**From:** [Ken Edwards](#)  
**To:** [Chace Pedersen](#)  
**Subject:** ACU-23-00004 ACX - Notice of Application  
**Date:** Tuesday, September 19, 2023 10:34:36 AM  
**Attachments:** [image001.png](#)  
[Screenshot 2023-09-19 103024.pdf](#)

**TO:** All Staff  
**FROM:** Public Works Plan Review Team  
**DATE:** October 4, 2023  
**SUBJECT:** Public Works Comments: ACU-23-00004 ACX

SITE PLAN
RECEIVED
 SEP 08 2023
 Kittitas County CDS
 ASIOI

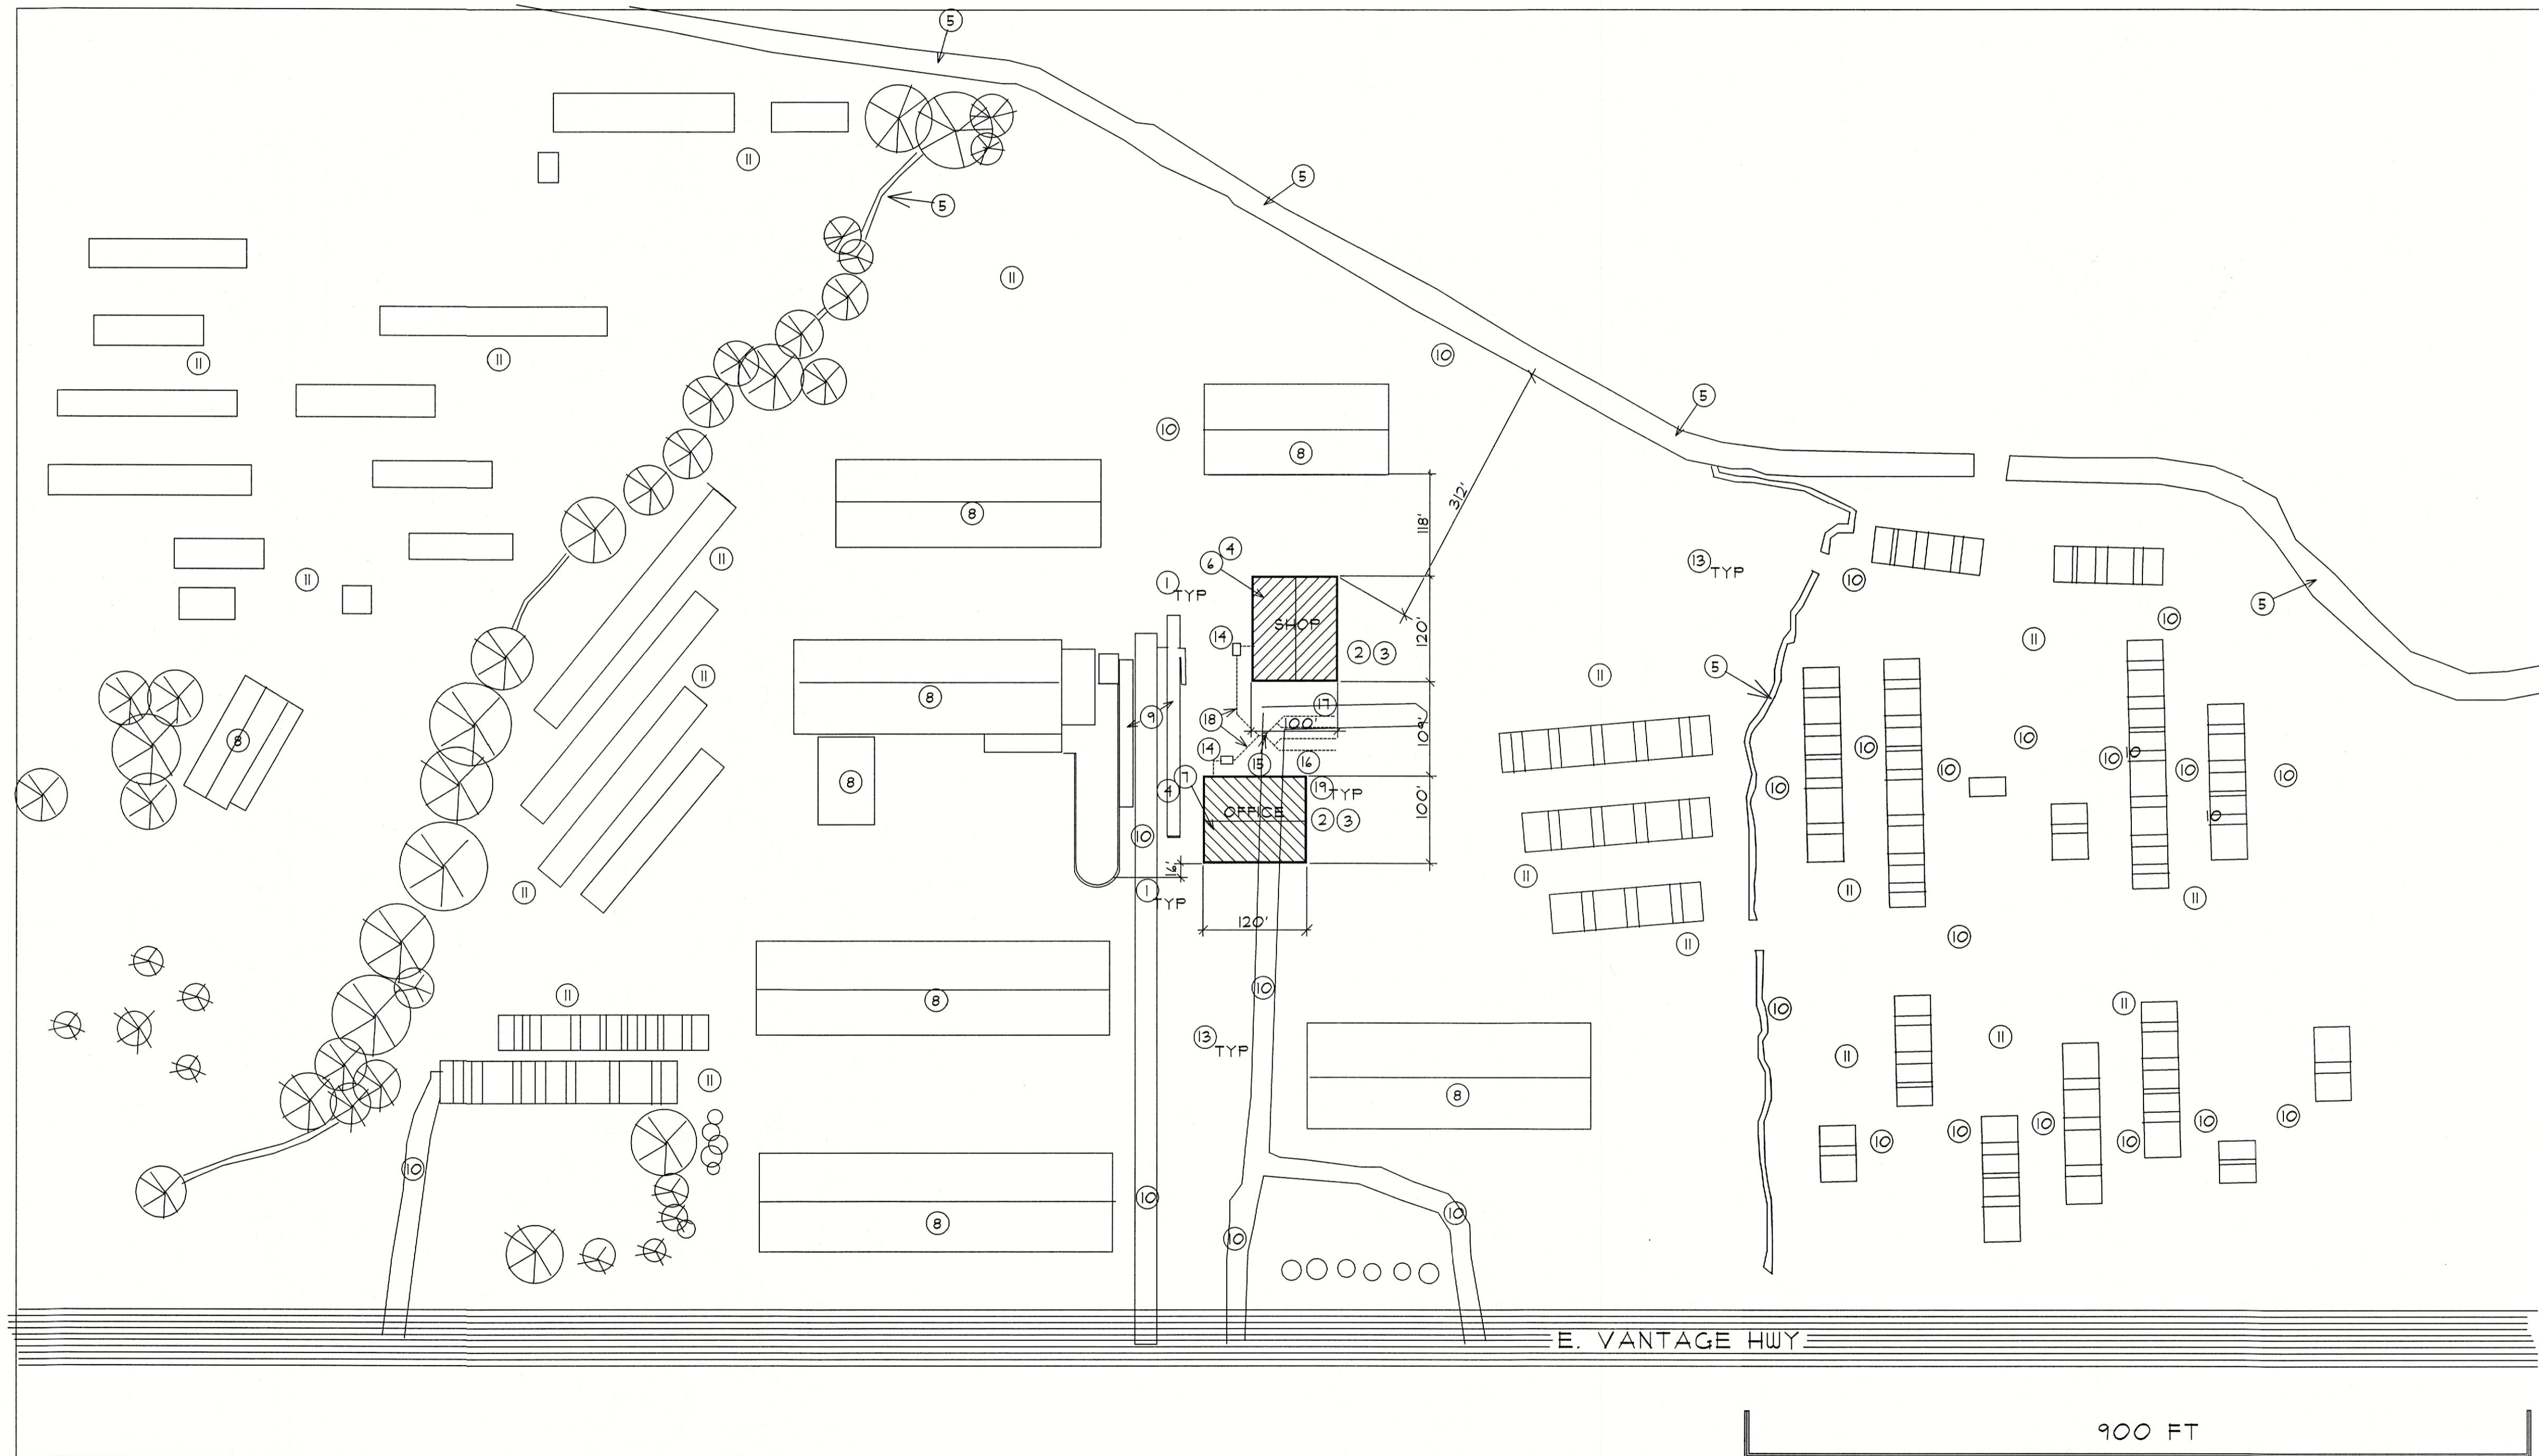
The proposed plan would require a relocation of existing underground primary power facilities. Developer should contact the Kittitas PUD for costs and requirements.

The parcel has a current on-site septic system permitted with Public Health for a bathroom only inside a shop. If no additions or alterations to this system are planned, then no on-site septic permit would be required through Public Health. If any additions or alterations are planned the system would need to be brought to current state and local standards. We would recommend the septic tank be pumped and the system inspected by a qualified individual prior to use.

I have no issues with the Conditional Use Permit, but the building will have significant requirements to meet the 2018 IFC requirements. These will include water supply, fire sprinklers, access, etc.
